From: Simon Davis
Sent: 15 February 2018 16:37
To: Planning.Responses
Subject: FW: FP/302/17/PL 10 Kingsmead - New Outbuilding

Drainage Engineers response

From: Paul Cann
Sent: 15 February 2018 16:22
To: Simon Davis
Subject: RE: FP/302/17/PL 10 Kingsmead - New Outbuilding

Nov 2017
1-100, 1-500
DRG 1.B.

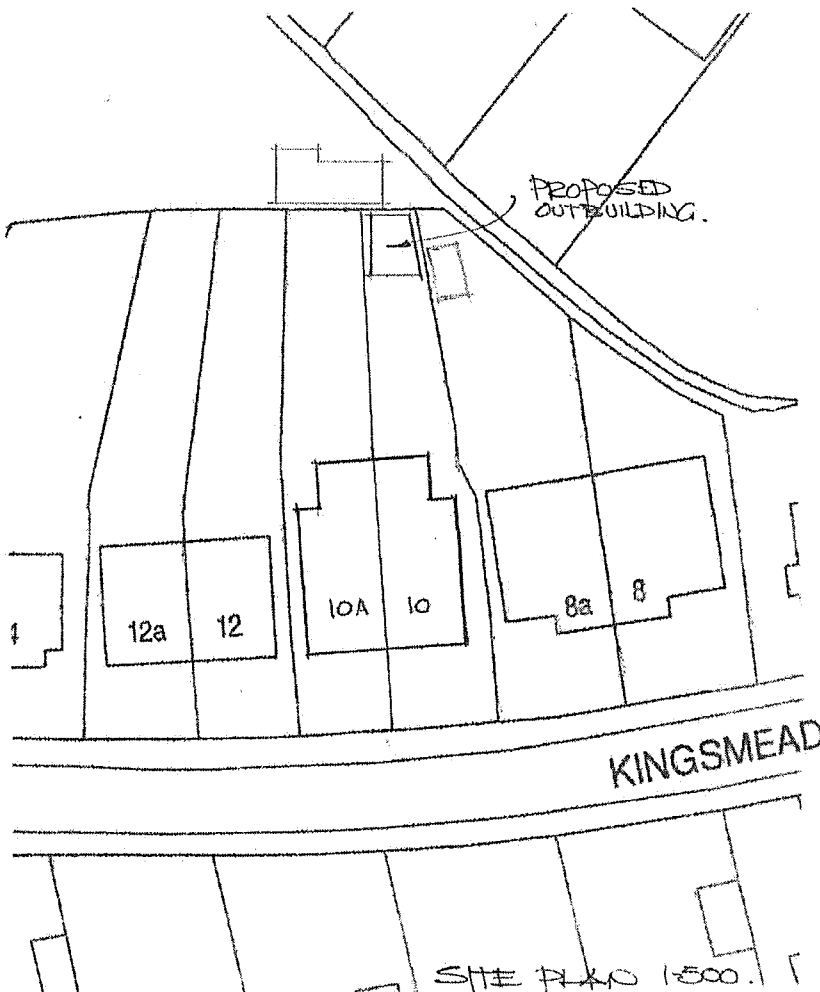
I wouldn't normally comment on such an outbuilding that is outside the Lidsey catchment area, however, now they have mentioned discharging to the soakaway that was approved under a separate application, that was not designed for the outbuilding, they will need to prove there is adequate capacity to accept the extra flows.
